AUDIO_AQUIND_ISH3_Session3_15122020

Thank you very much, Mr. Mann. Apologies to everyone. If I fade in and out. I'm having one or two connection issues, but hopefully that shouldn't interfere with our running of the hearing. Moving on to item six k on the agenda in relation to noise. We've referenced it x q one question and 111 three, could the applicant clarify the meaning of its response and I quote within the onshore cable corridor, the relevant distance between the illustrative cable route and the noise sensitive receptors influences the magnitude of noise level experienced by receptor. The magnitude of impact on overall noise effects assigned to this magnitude of level is influenced by the duration, timing and frequency of exposure to that noise level, which is not altered by the alignment of the cable route. Unquote. The first part of that suggests that the distance between the cable and a receptor does not influence does influence so the impact perceived that the receptor Might intuitively be expected as noise diminishes from source. The second part could be taken to contradict this. Please, could the applicant provide clarification and what is meant by that? Mr. Jarvis? Wi

DRAWING NO: EN020022-ES-24.2-Sheet2	REV.NO. 01
---	---------------

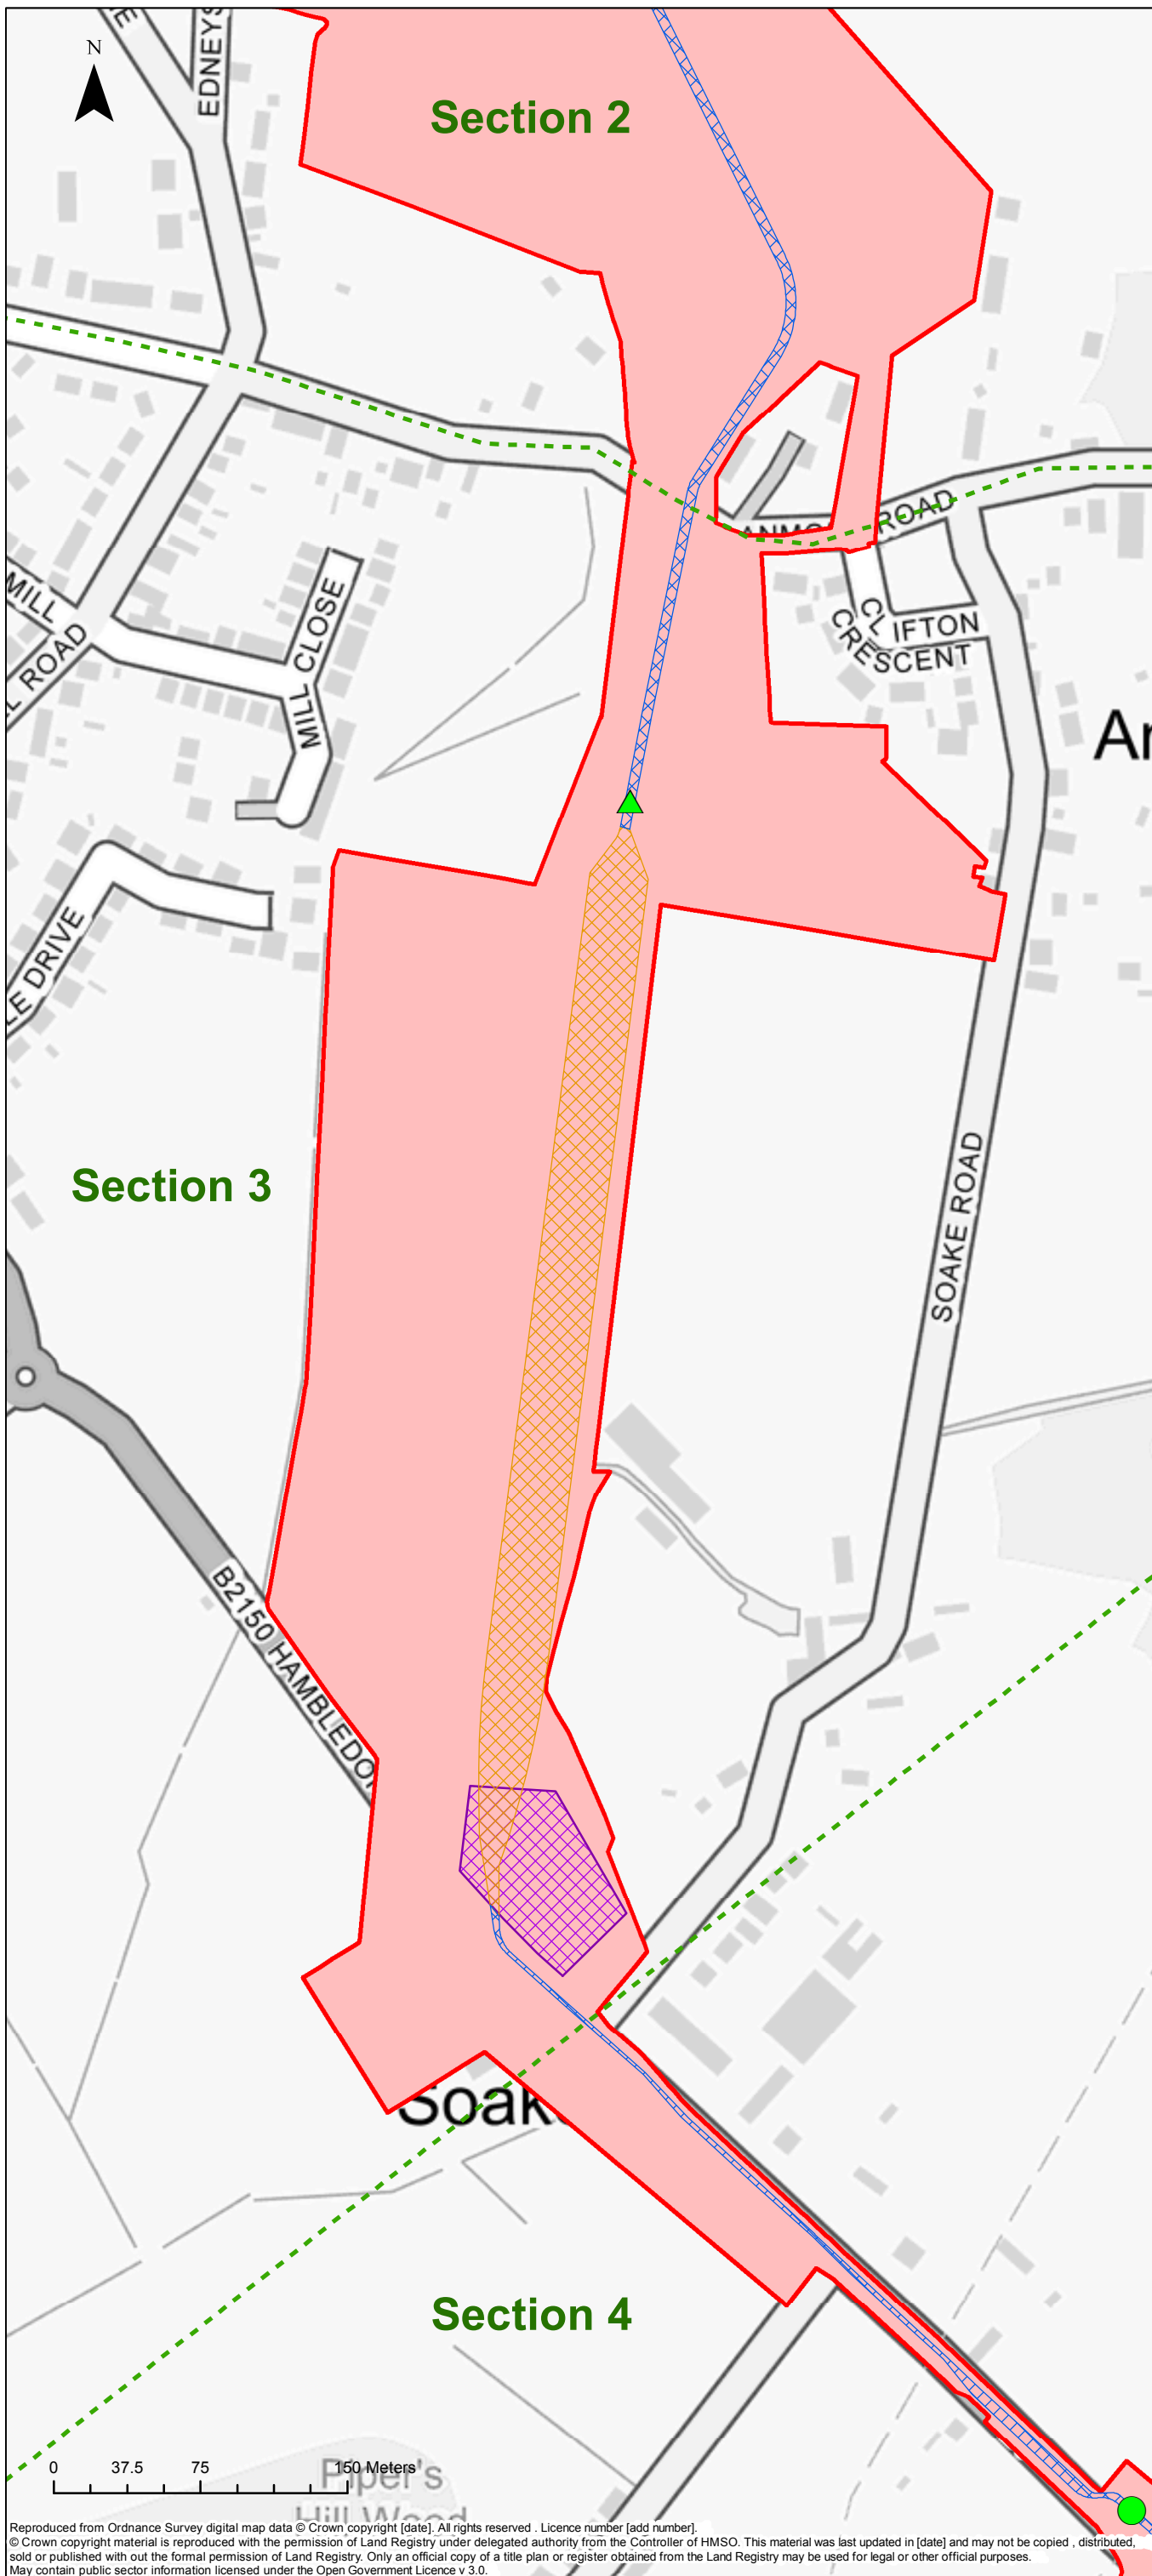
Okay, okay. Thank you very much for that. Hopefully, you've got that plan on screen in front of you now. I'm just seeing it to the the bottom left of the image there those properties in add nice line? Yeah. Can I just confirm that if, if the cable route, where to differ from that illustrative routes, and where to head over for whatever reason, towards that southwest corner? Can I just confirm that it is your position that no matter how close it got to those properties, that there would still not be an adverse effect of noise upon them?

That's correct, sir. Because those properties are located further than 22 metres from the order limit boundary.
